**RE: AIS – Indian Pueblo Center
1120 Indian School NW
Grading and Drainage Plan Stamp Date: 12/16/19
Hydrology File: H13D009**

**RE: AIS- INDIAN PUEBLO CENTER
1120 INDIAN SCHOOL NW
GRADING AND DRAINAGE PLAN STAMP DATE: 9/6/19
HYDROLOGY FILE: H13D009**

Per your correspondence dated December 12, 2019, please find the following responses addressing the comments listed below:

POST DEVELOPED DRAINAGE PLAN  
SEC OF 12TH ST. & INDIAN SCHOOL RD., ALBUQUERQUE, NM

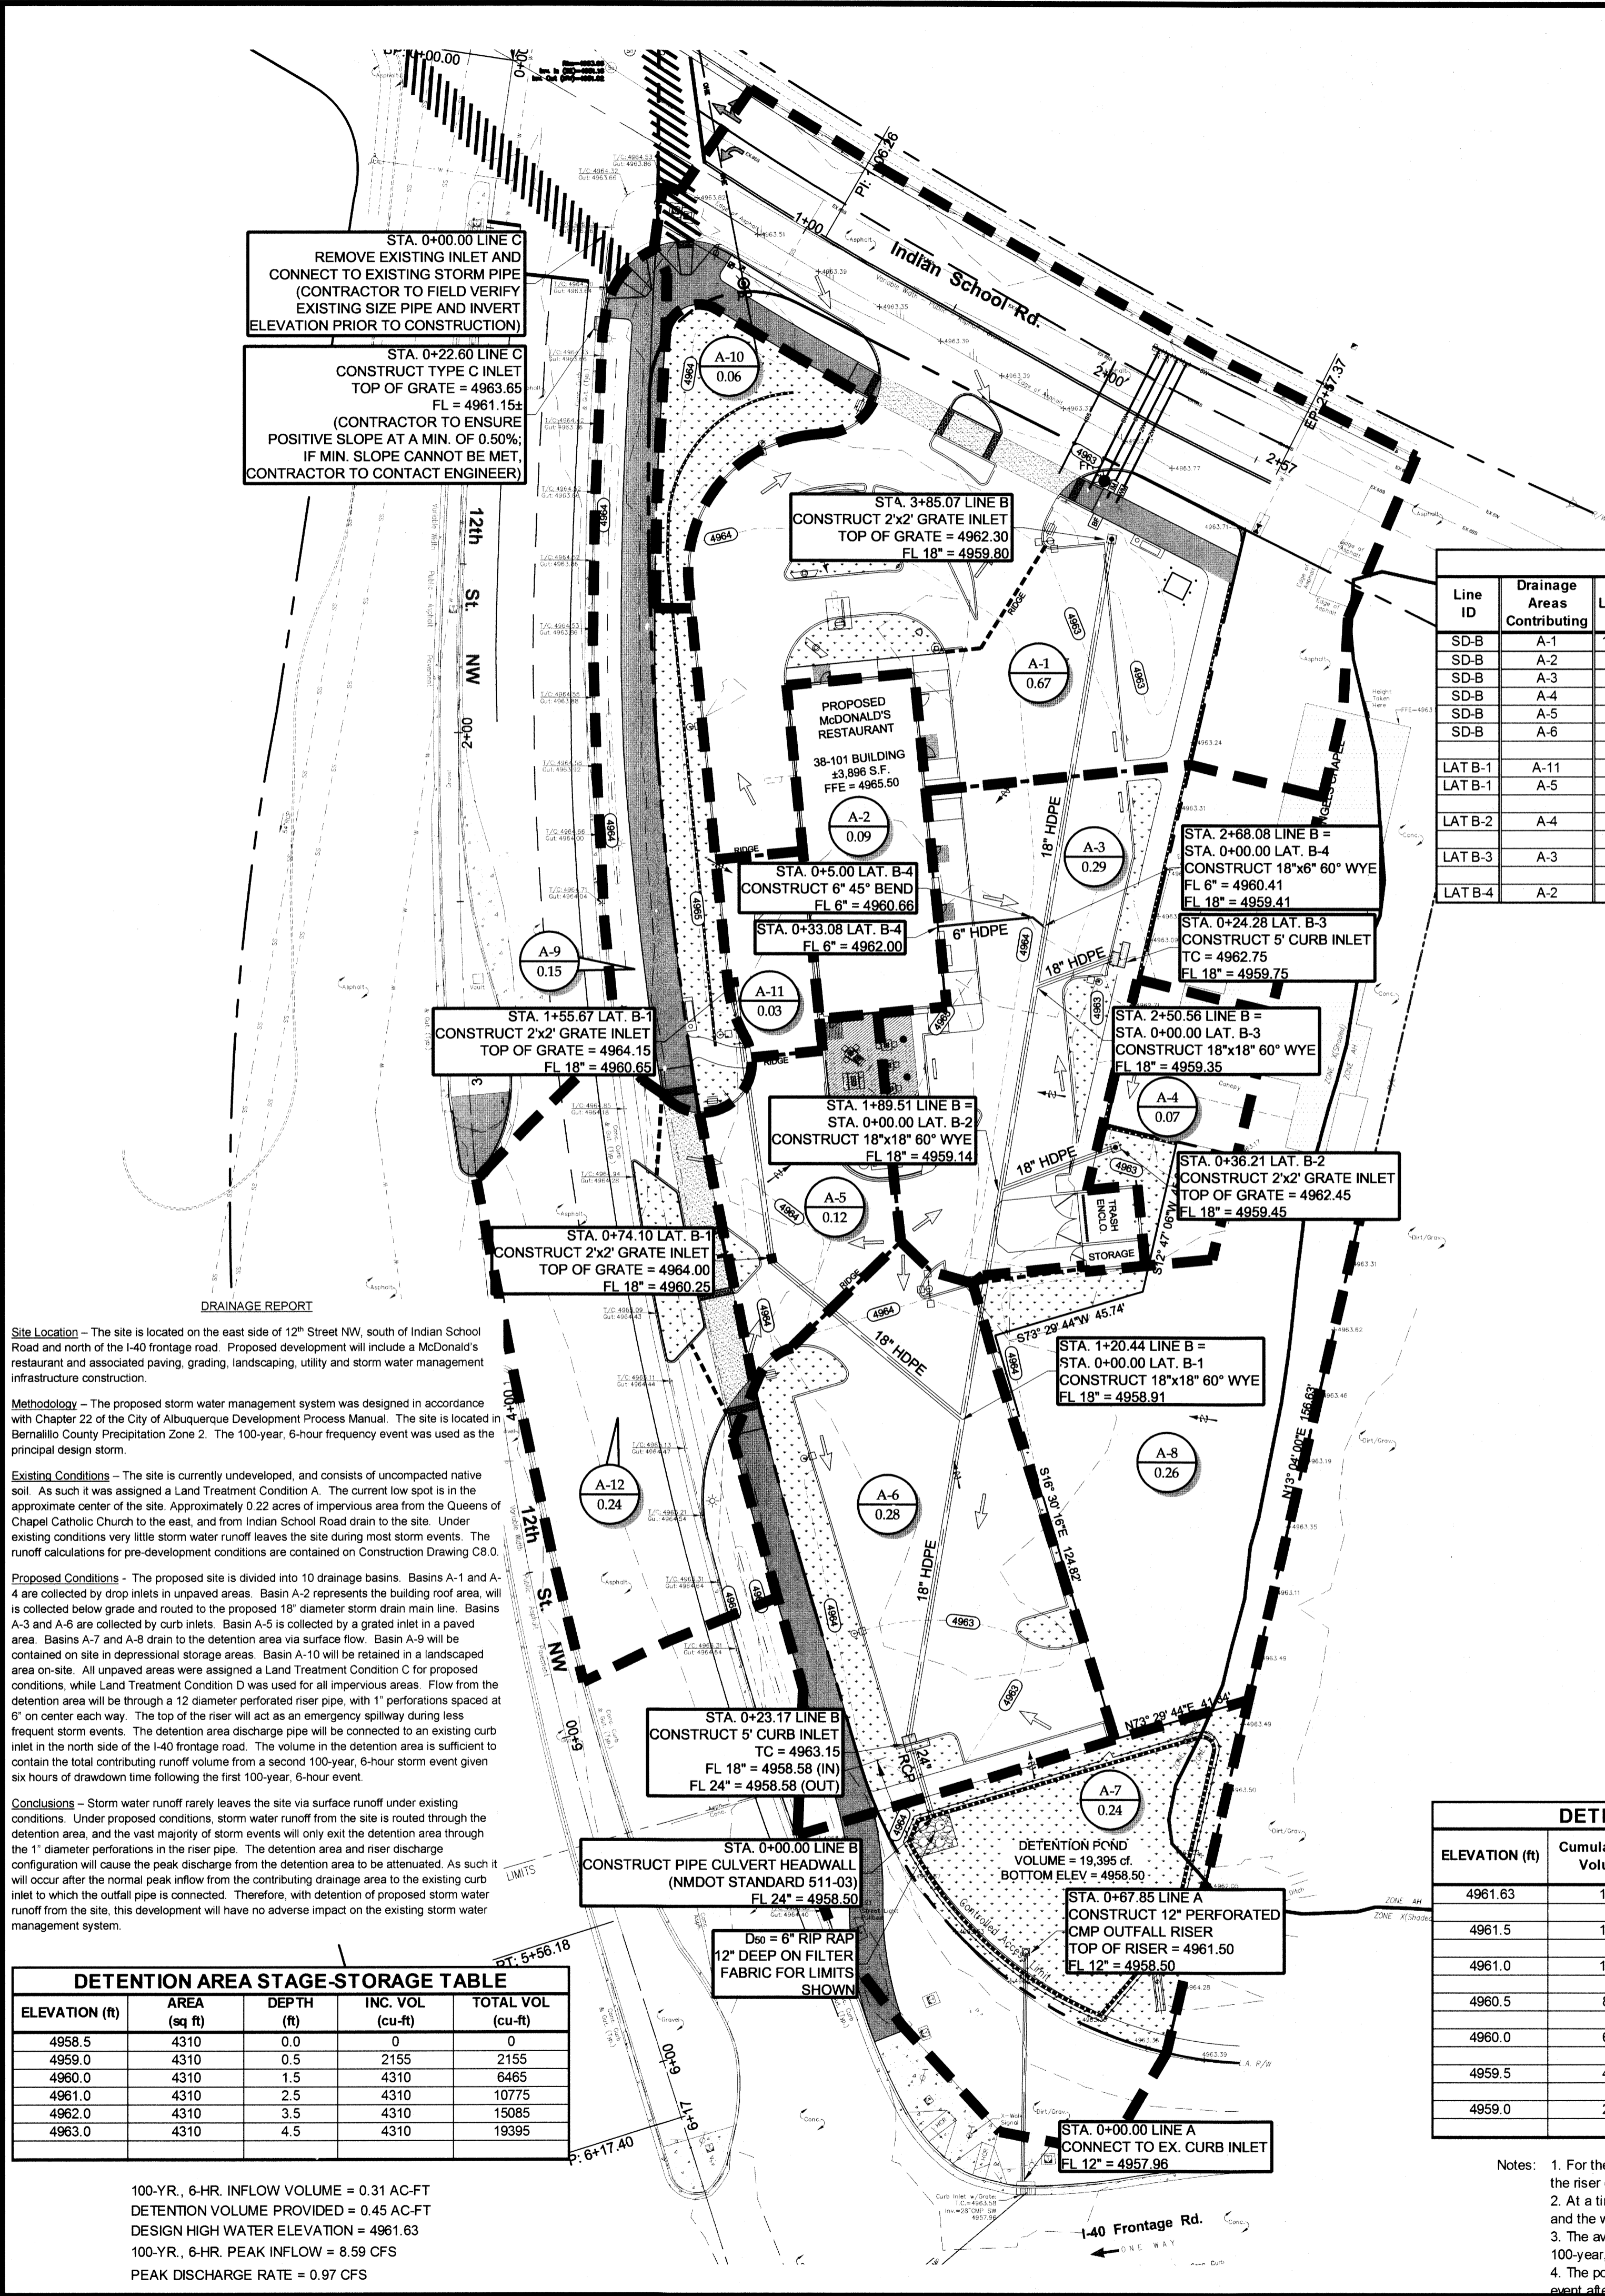
3. Provide pond sizing and volume calculations for the new pond.

This depressed area is a water harvesting area as opposed to a pond. The pond volume for this parcel is already accounted for in the existing pond located to the southwest of this parcel as shown on the approved overall drainage plan previously submitted.
